# DEPARTMENT OF PLANNING & INFRASTRUCTURE

## **SUBJECT: MODIFICATION TO THE PROJECT APPROVAL FOR THE REDEVELOPMENT OF SYDNEY SHOWGROUND MAIN ARENA AT SYDNEY OLYMPIC PARK (MP10 0145 MOD 1)**

To determine a modification request for design changes to the redevelopment of the Sydney Showground Main Arena at Sydney Olympic Park.

Stage 1a - Long Elevations

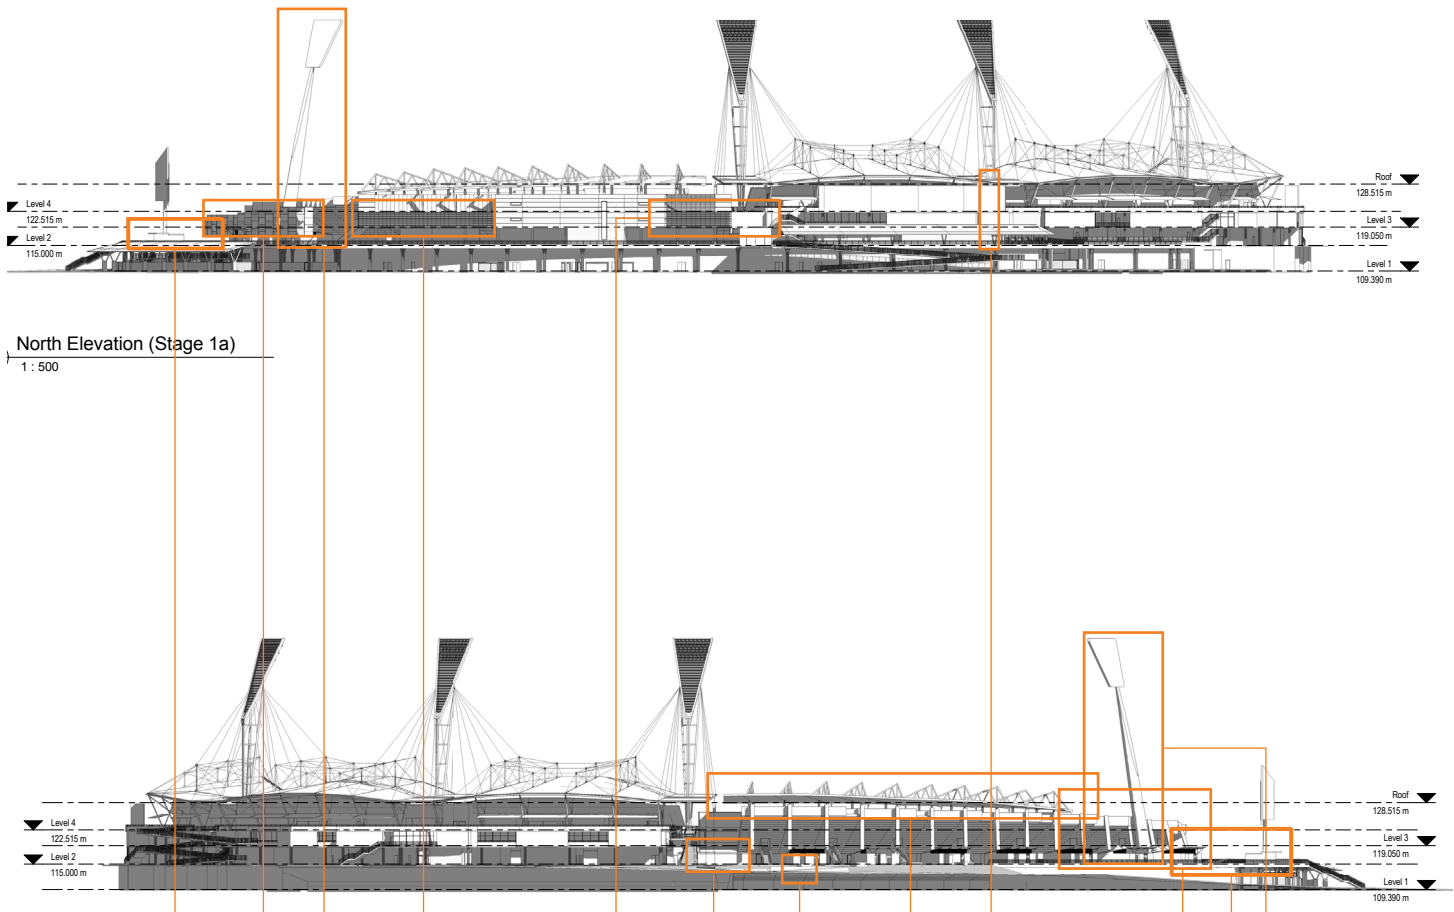
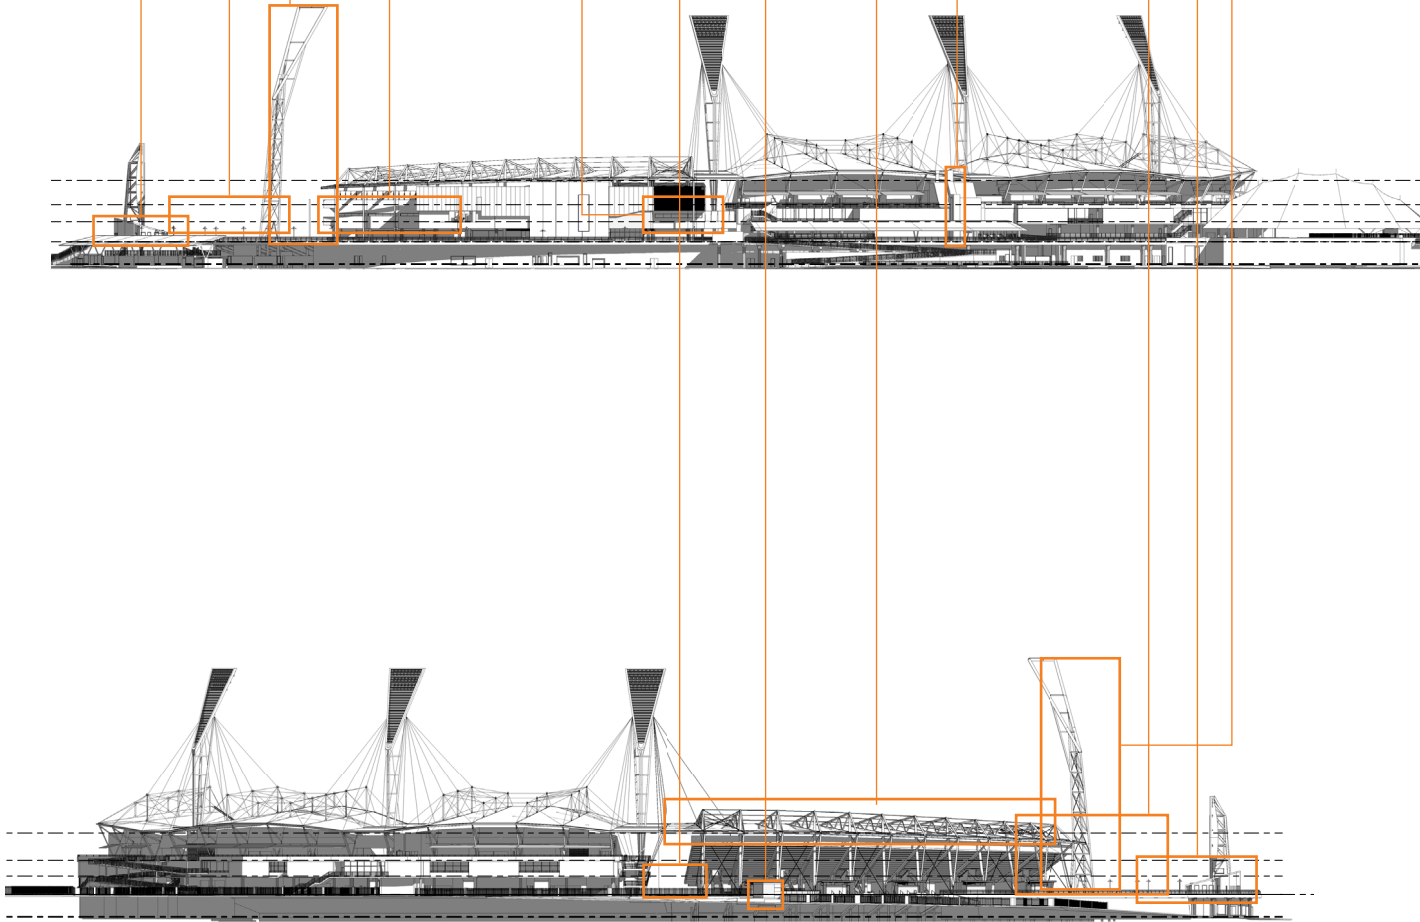
- the relocated new lighting towers should be at an equivalent height to existing towers and it should be demonstrated that they would not interfere with Stage 2 works

- the new lighting towers are required to be taller to ensure a matching headframe to the existing lighting towers can be installed and meet the functional requirements of adequate luminosity for sporting matches

In a further letter to the Department dated 20 September 2011 in response to the proponent's August submission, SOPA identified that lighting masts should be consistent with the height of the existing masts, which the proponent has since indicated can be achieved. Revised plans have subsequently been submitted on 27 September 2011 to demonstrate that the light masts will match the existing light masts in terms of shape and height.
